WEST SUSSEX COUNTY COUNCIL CONSULTATION

TO:	Arun District Council FAO: Amber Willard
FROM:	WSSC – Highway Authority
DATE:	18 March 2026
LOCATION:	Land East Of The Croft Surgery Barnham Road Eastergate PO20 3RP
SUBJECT:	BN/10/26/PL Approval of details reserved by condition under BN/38/24/PL relating to conditions 5, 7, 16, 19, 20, 21, 22, 23 & 24. (See Application BN/12/26/DOC for conditions 8 & 9 - drainage). Additional plans received.
DATE OF SITE VISIT:	n/a (desktop study undertaken for purposes of this planning application)
RECOMMENDATION:	Advice

This is the **second** WSSC Highways response to the above planning application seeking approval of details reserved by condition under BN/38/24/PL relating to conditions 5, 7, 16, 19, 20, 21, 22, 23 & 24.

Comments below specifically respond to highways-related condition 16 (secure and covered cycle parking).

Description:
EXTERNAL WORKS Sht6

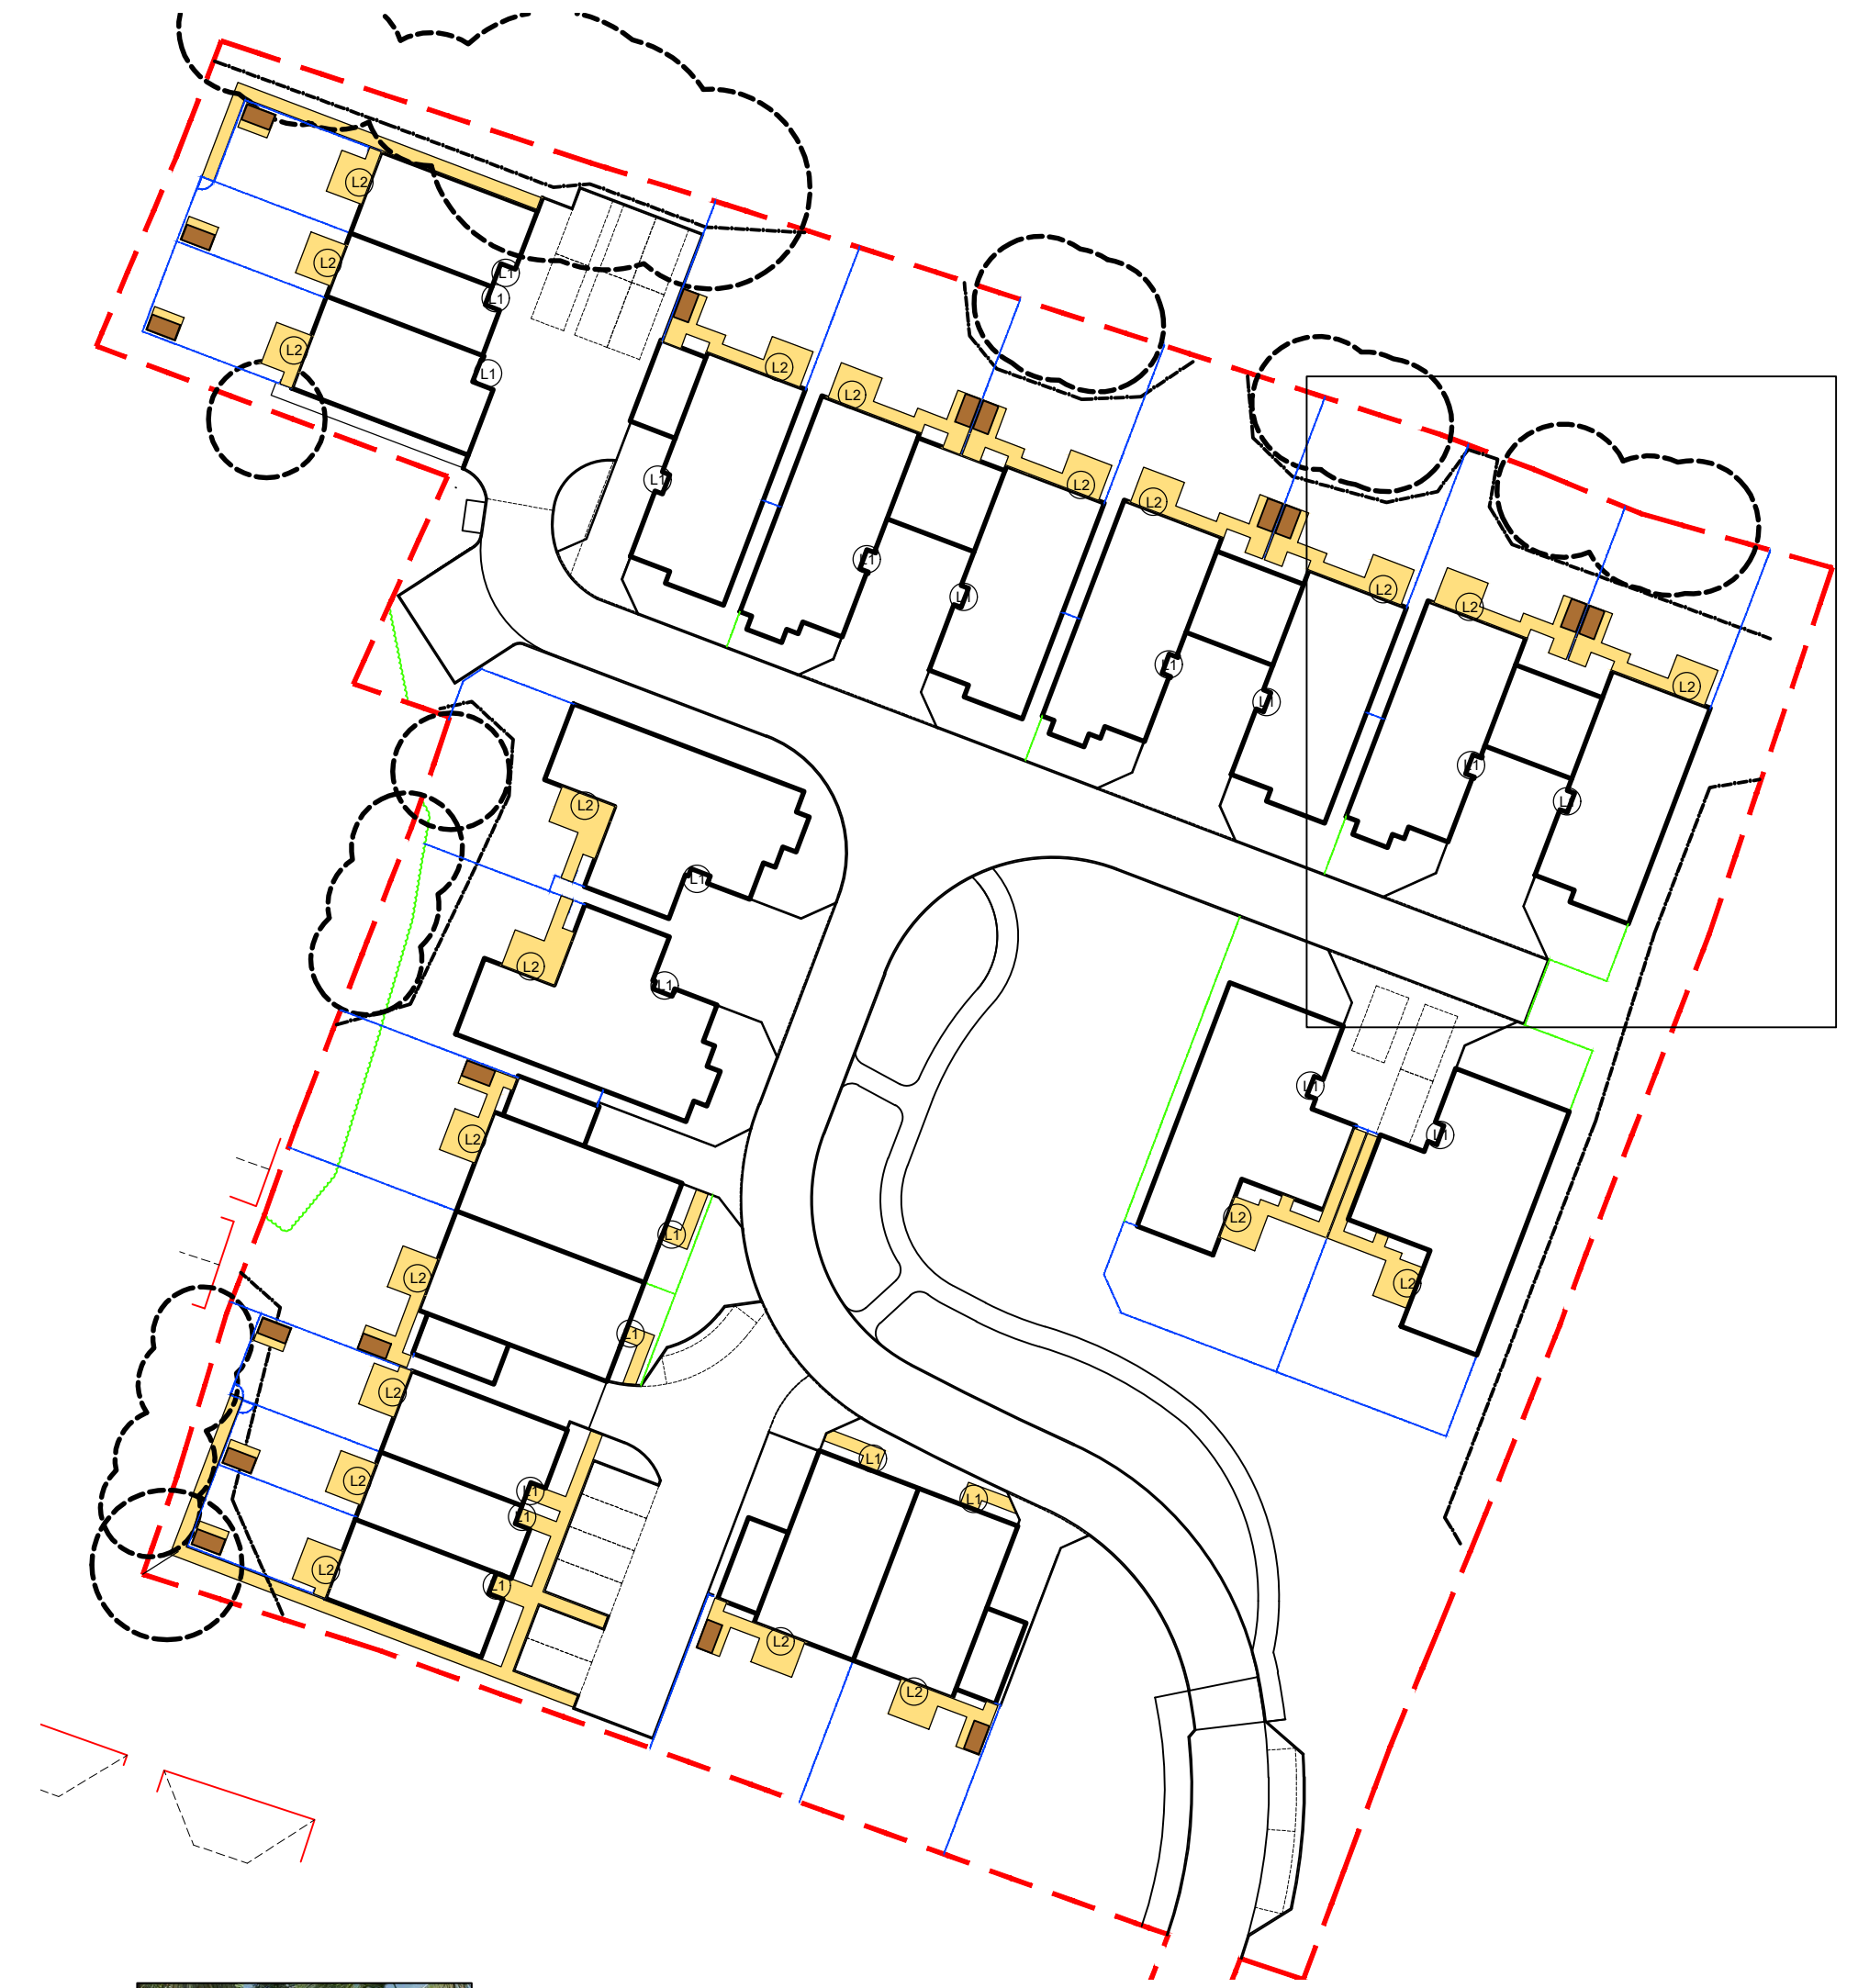
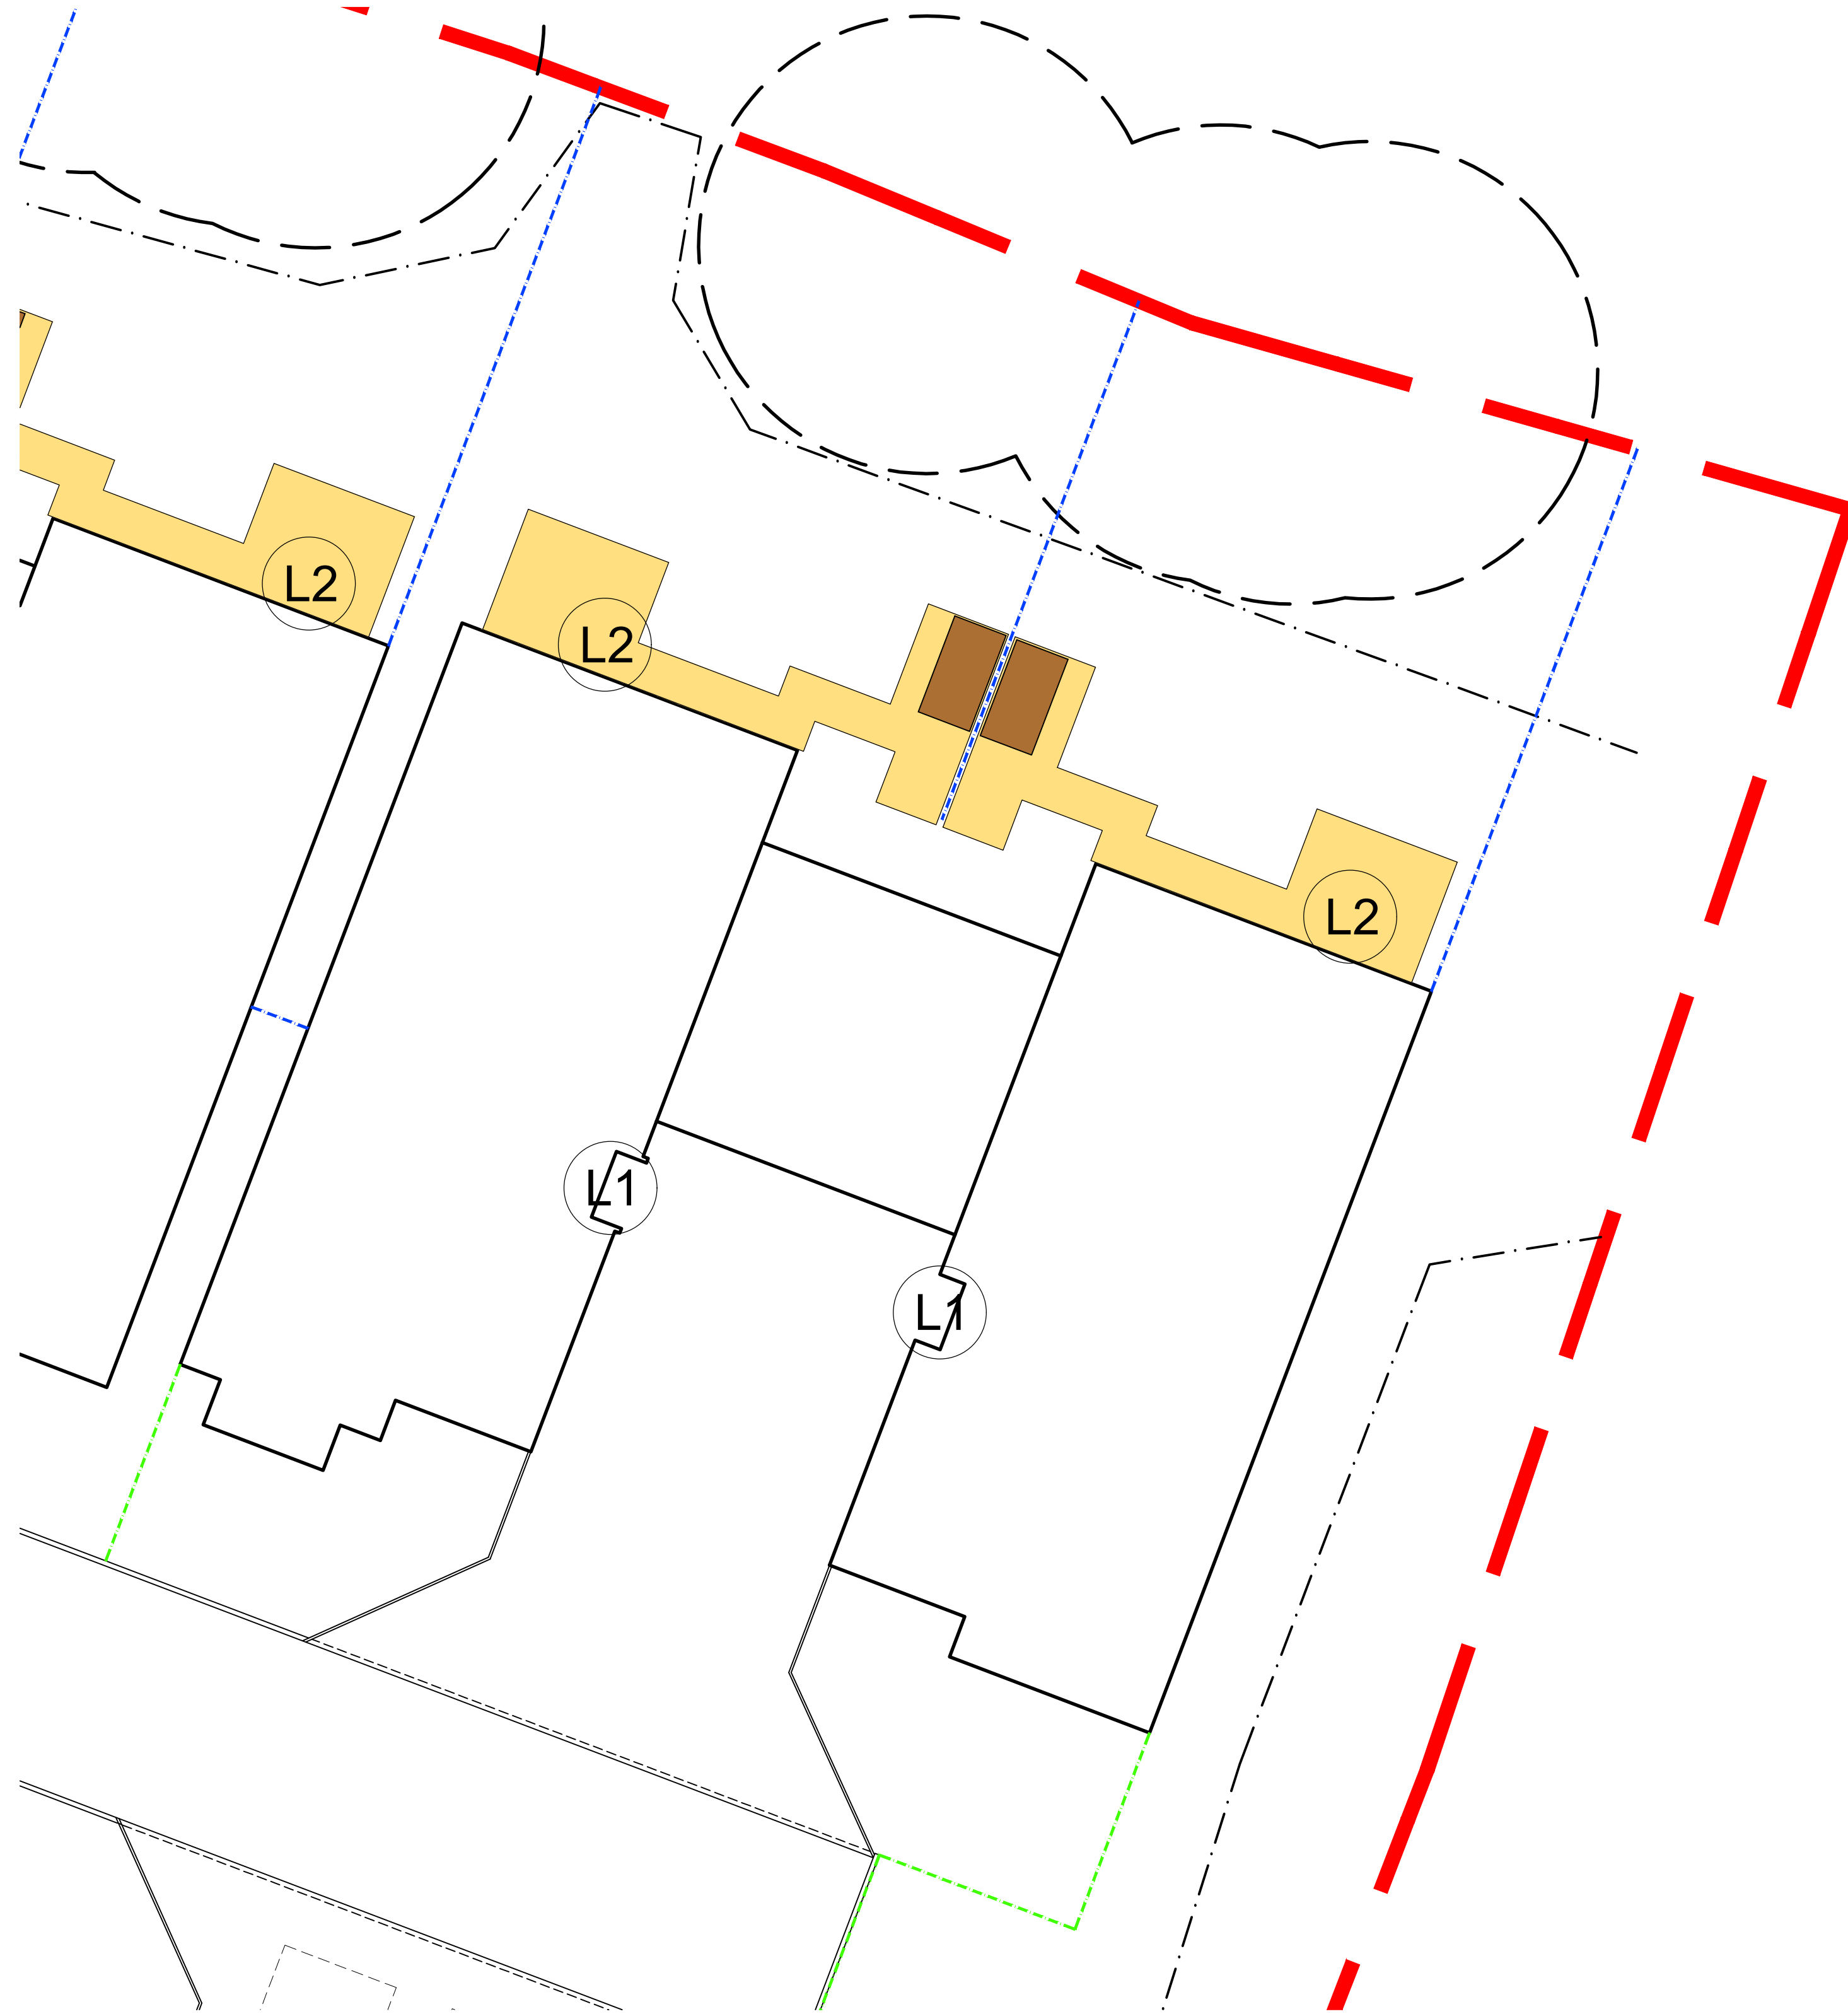
- (1)** The following extracts, taken from the external works plans, show the plots where it is not clear how access to the bicycle storage will be achieved from the access road. Applicant to provide details, please.

(2) And for the following (overleaf), no cycle storage is shown. Applicant to amend, please.

Drawing Number 2645-TFC-XX-00-DR-L-1001, revision P02, produced by Terrafirma Landscape Architects, now shows how cycle storage for each dwelling will be accessed.

This is also now shown (within garages) on Drawing Number 2645-TFC-XX-00-DR-L-1001, revision P02, produced by Terrafirma Landscape Architects.
